PUBLIC WORKS DEPARTMENT  
CITY ENGINEER OFFICE  
DRAINAGE SECTION

COMPLAINT FORM

Re: Storm Water Drainage Problem

PARKING LAYOUT

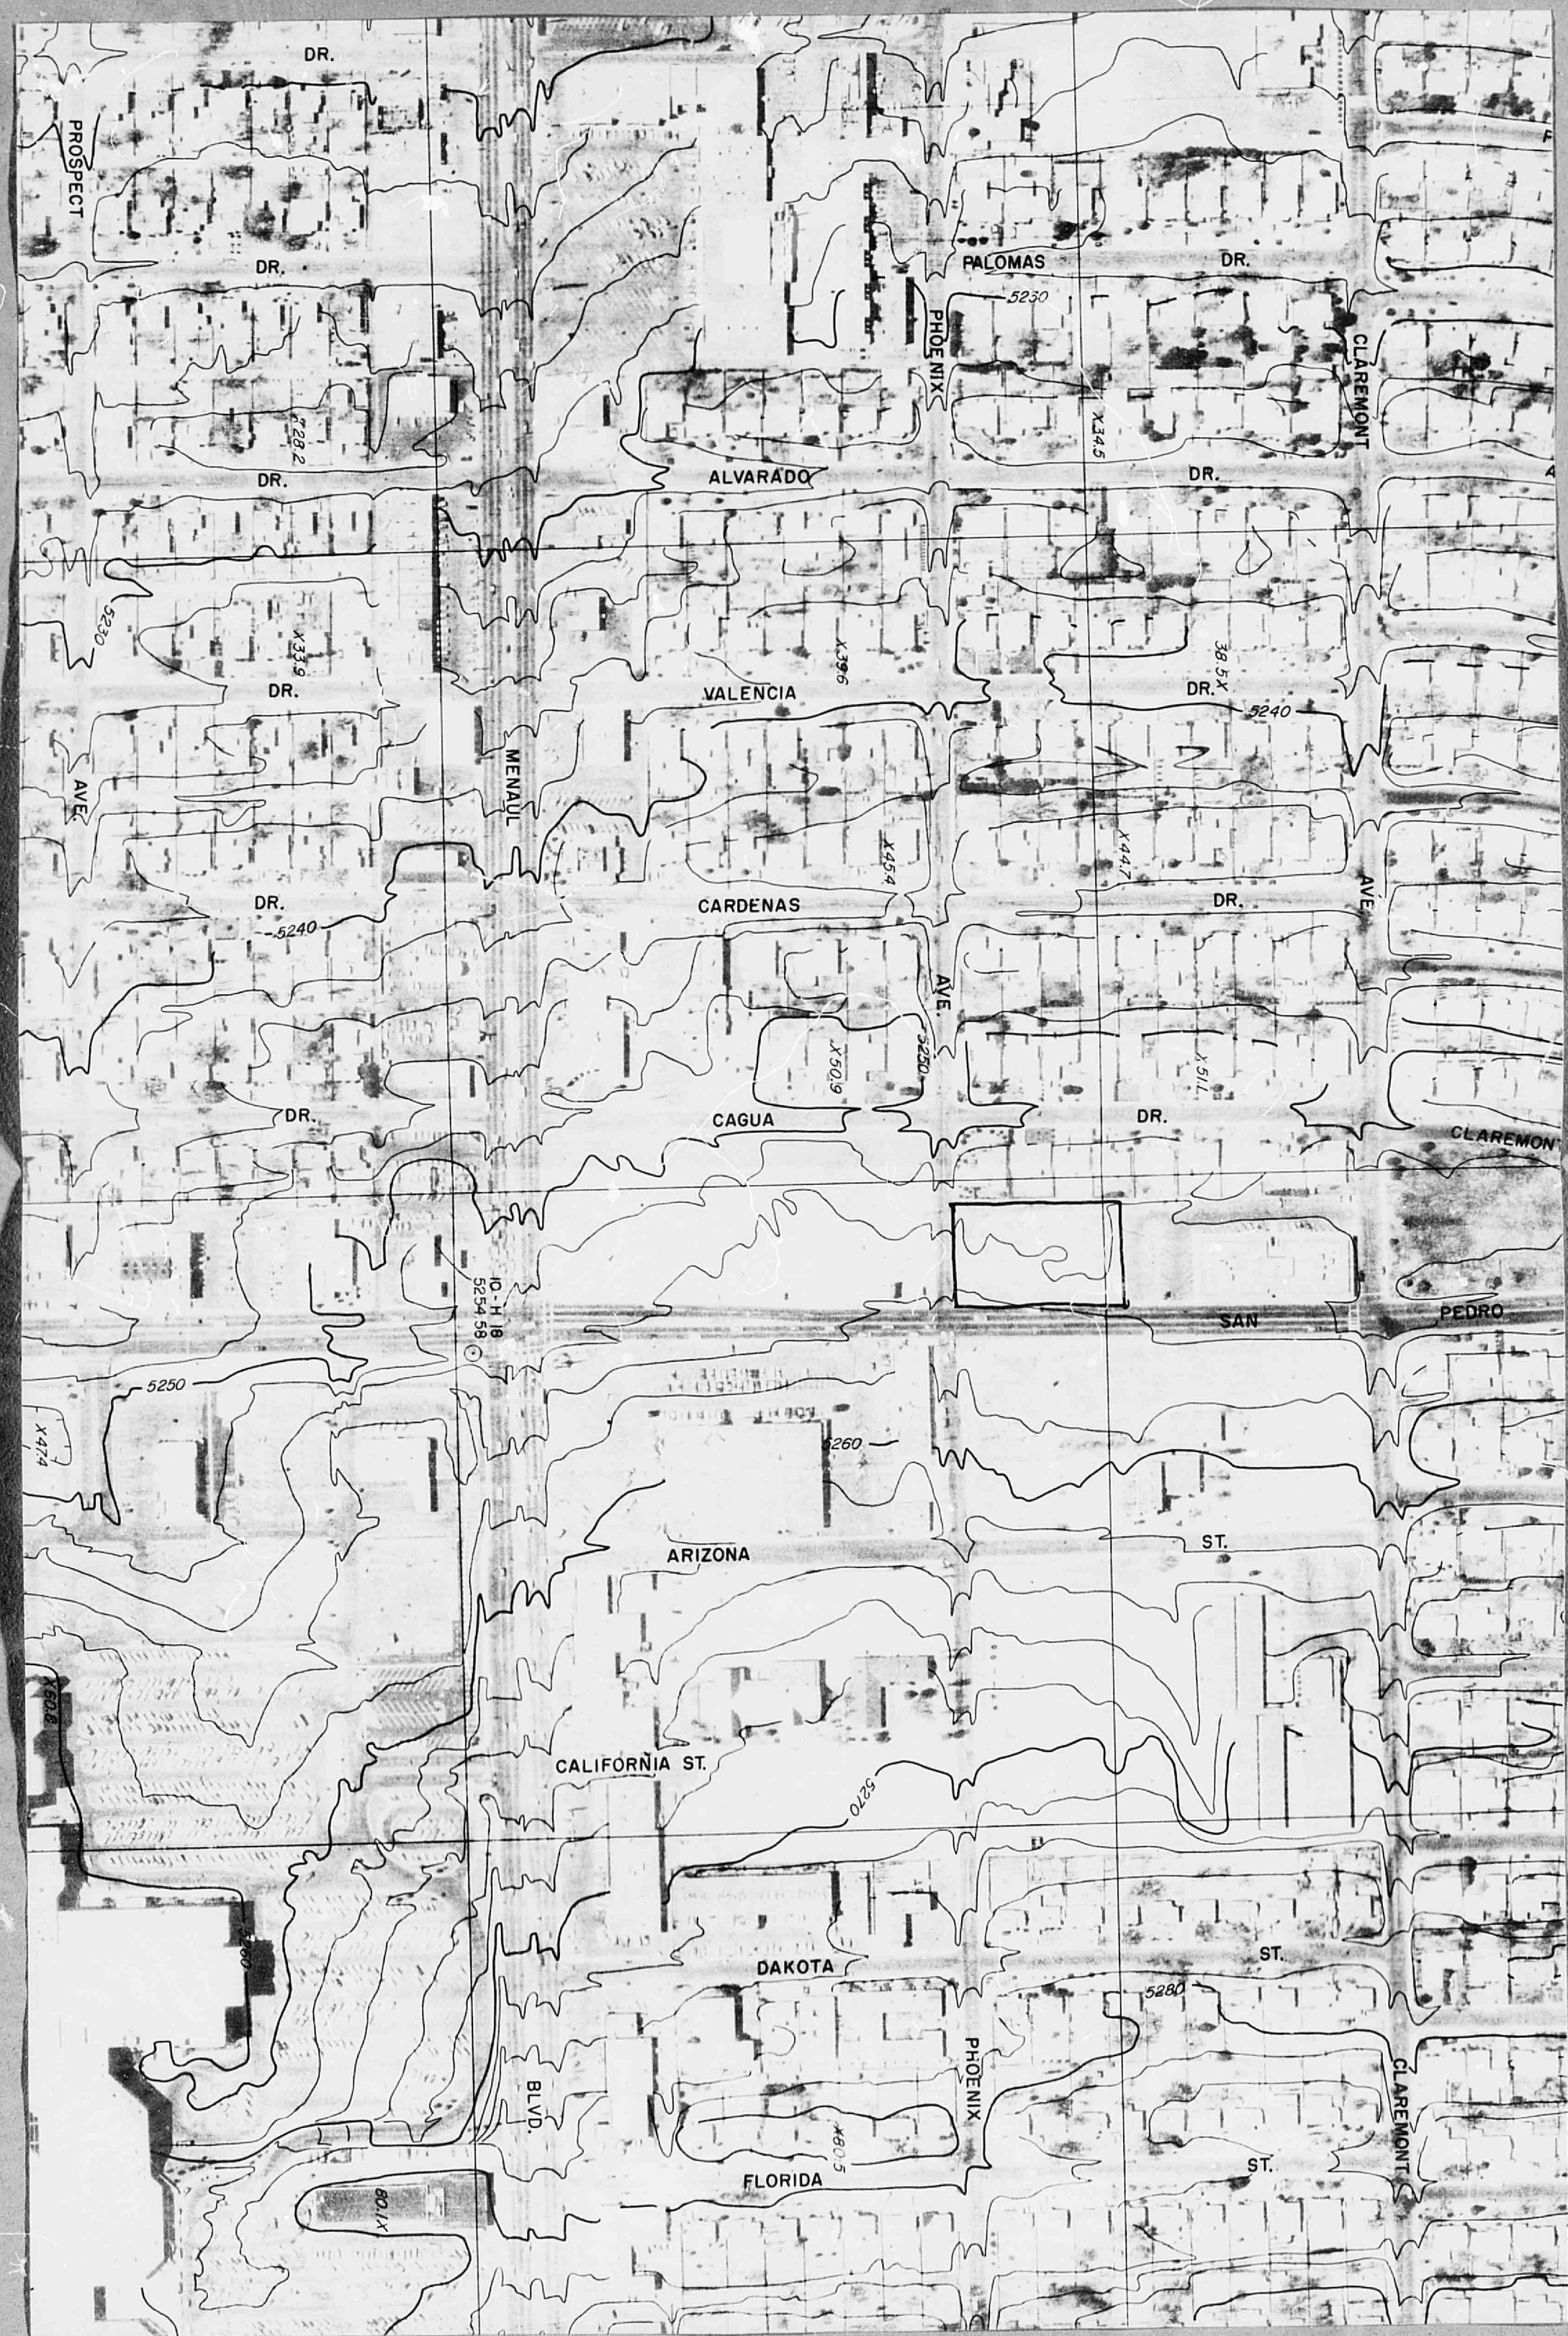
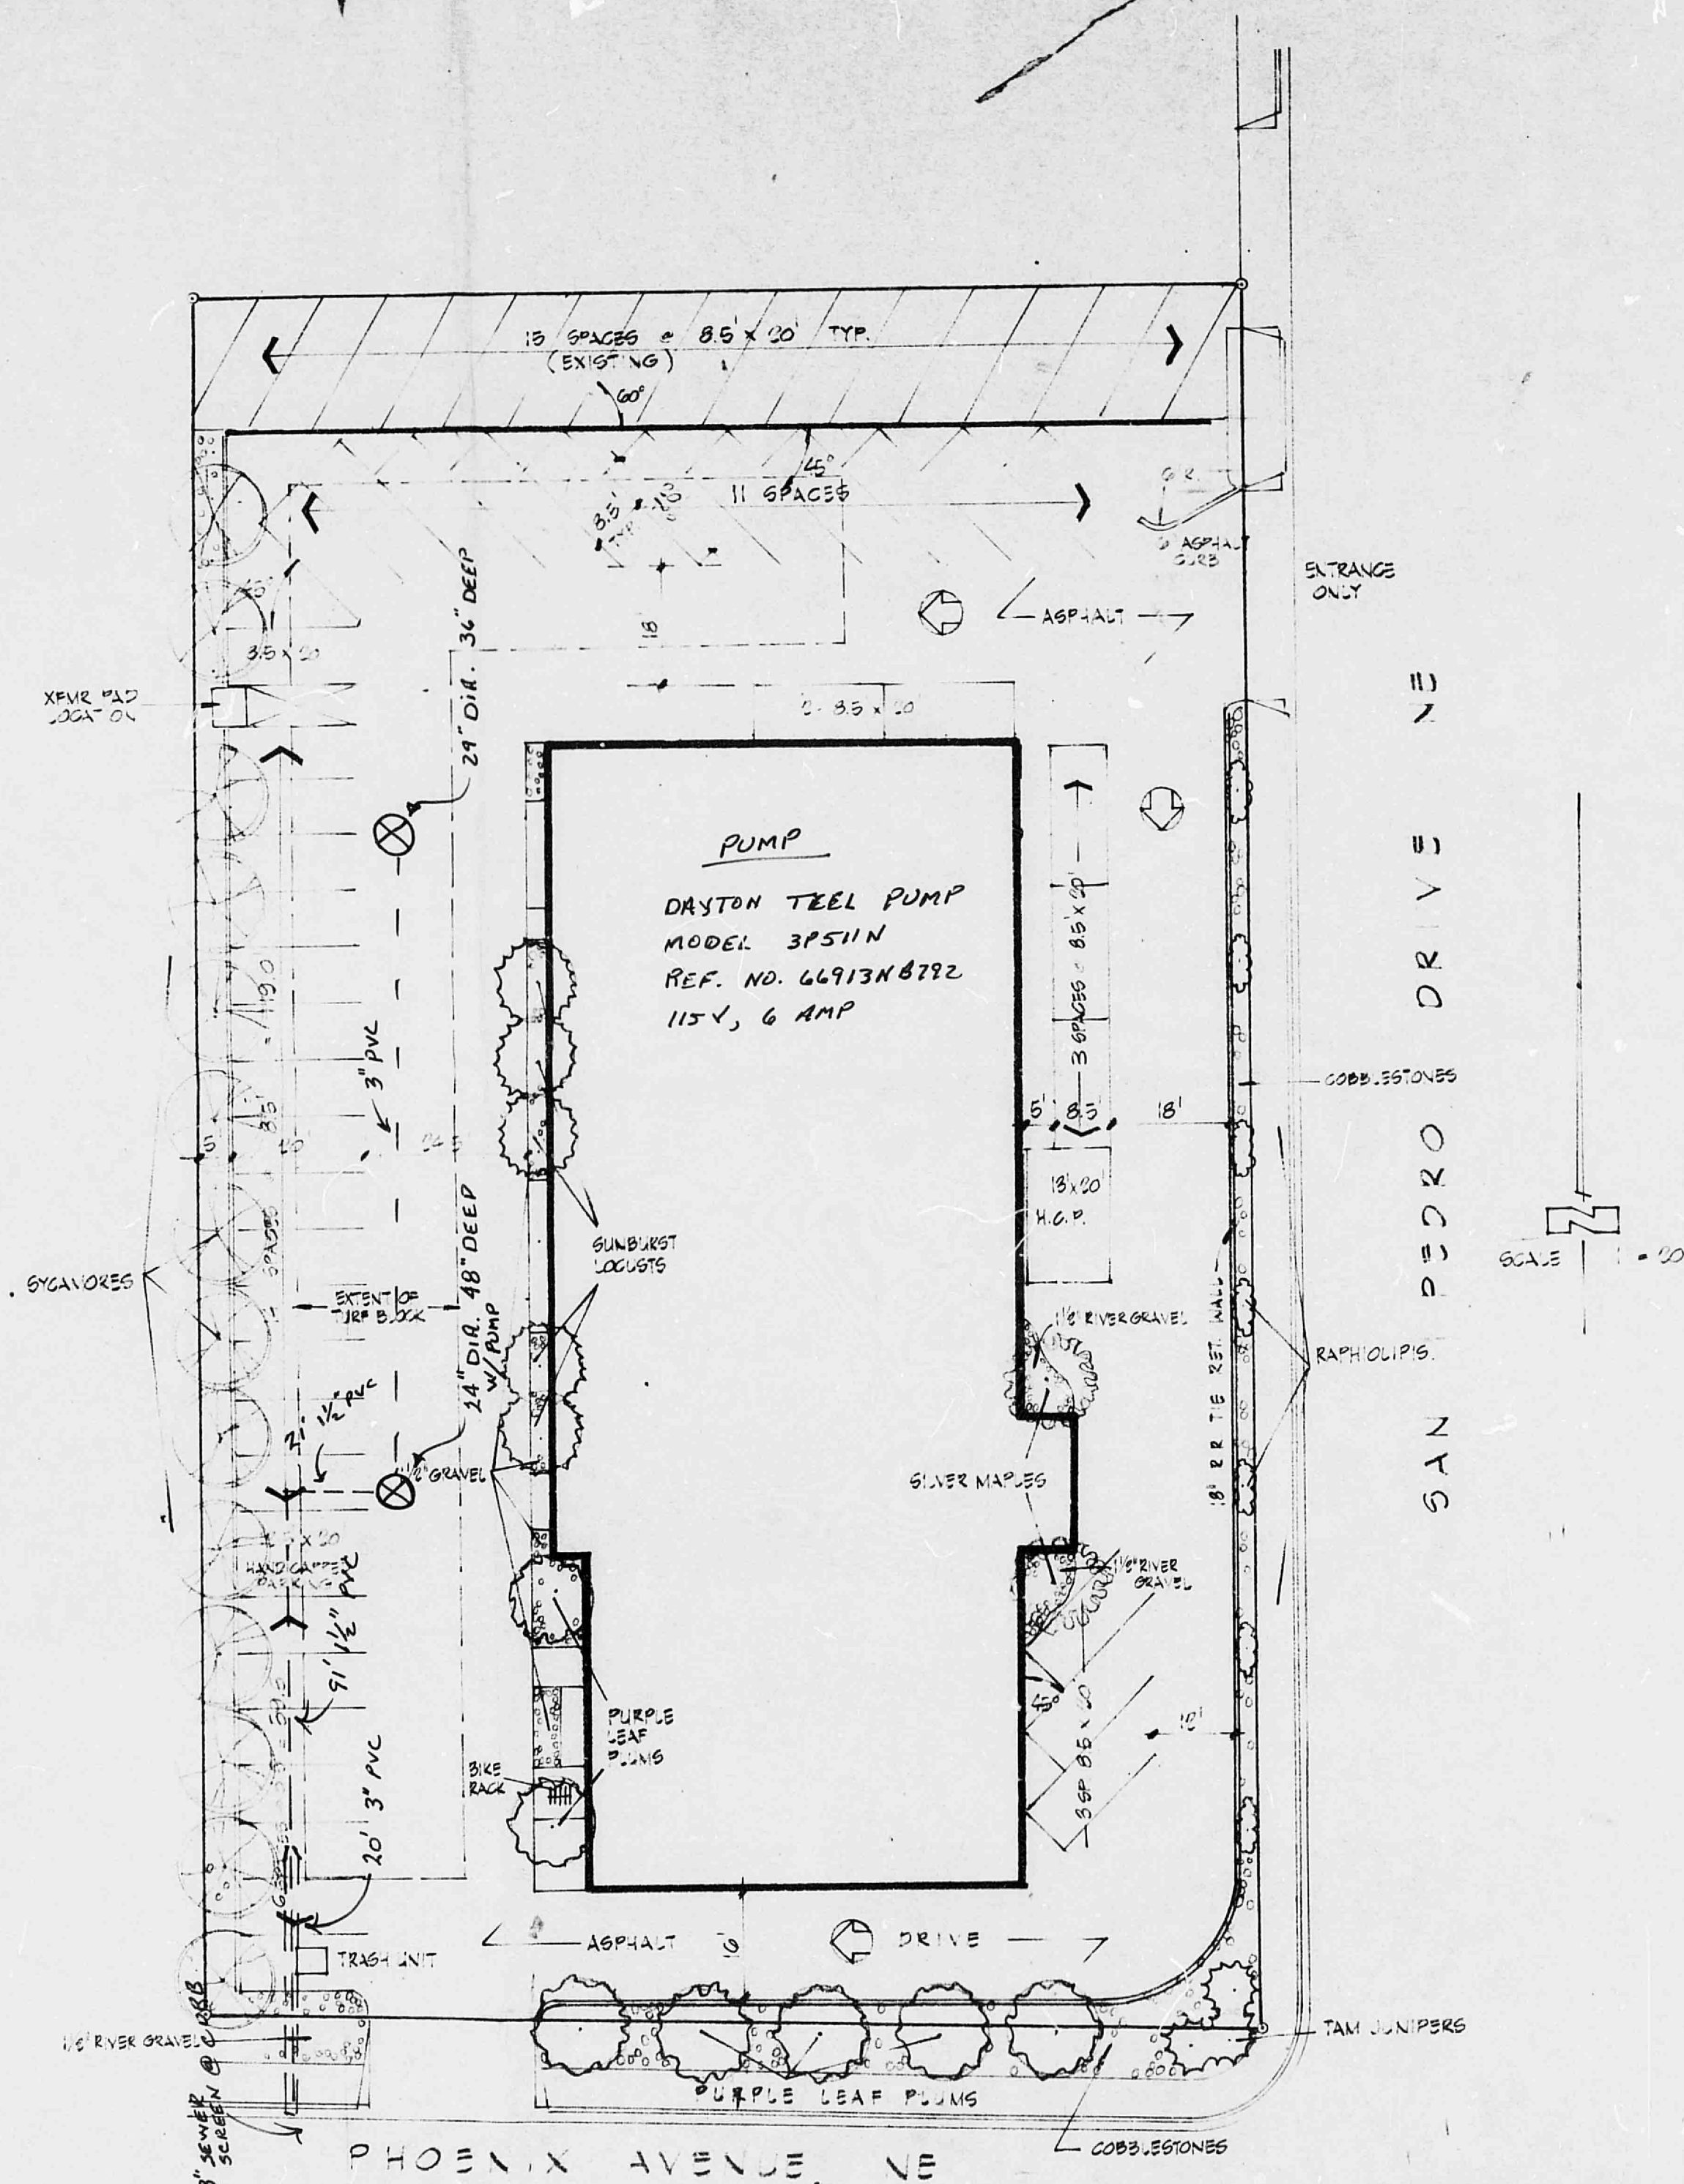
Report of Investigation: THERE IS A RETAINING WALL IN THE NORTH SIDE OF THE BLDG. THAT IS BLOCKING THE WATER COMING FROM THE SIDE. NEXT TO THE STONE CO. BLDG. AND THIS MAKE WATER POND. IN THIS IS PRODUCING A PROBLEM FOR THE WALL THAT ~~IS~~ IS IN THE WEST SIDE. (SAM CORDOVA)

This is to advise you that the storm water drainage from your building lot at the subject address is illegally tied-in to the sanitary sewer system. This is in violation of our sewer use ordinance specifically part (1) of Section I which states, "No person shall discharge or cause to be discharged any storm water, surface water, ground water, roof runoff, or subsurface drainage to any sanitary sewer." A sanitary sewer is defined as follows, "Sanitary Sewer shall mean the public sewer portion of the wastewater treatment works and to which storm, surface and ground water are not intentionally admitted."

Recently our field crews "smoke and dye tested" the public sewer system in response to a citizen complaint and the work revealed that the lot drainage is tied into your sanitary service line within your property with the service line connected to our sewer on San Pedro.

We have reviewed the approved drainage plan with personnel from the Municipal Development Department and find that the plan calls for an on-site drainage system. This is the only alternative which could have been approved by the City since a storm sewer system is not available in this area. The plan we are referring to was prepared by Enchantment Engineering and is dated October 9, 1978. We are told that at one time such a system was installed but later the area was paved over and a pump and force main system installed.

PROVED TUFF TURF AREA AND  
INCORPORATED TWO INLETS  
WITH A PUMP. THIS PUMP  
WAS CONNECTED TO THE  
SANITARY SEWER. ED ARCHULETA  
FROM WATER RESOURCES MADE  
THEM REMOVE IT. THEY ASKED  
US IF THEY COULD CONNECT  
IT TO THE CURB AND DRAIN IT  
THERE. WE GAVE THEM PERMISSION  
TO DO THAT BUT ADVISED THEM  
THAT THE PUMP MIGHT NOT BE  
ADEQUATE IN CASE OF A BIG STORM.

Please be advised that you must correct the situation within thirty days from receipt of this letter or show cause as to why you cannot correct the matter.
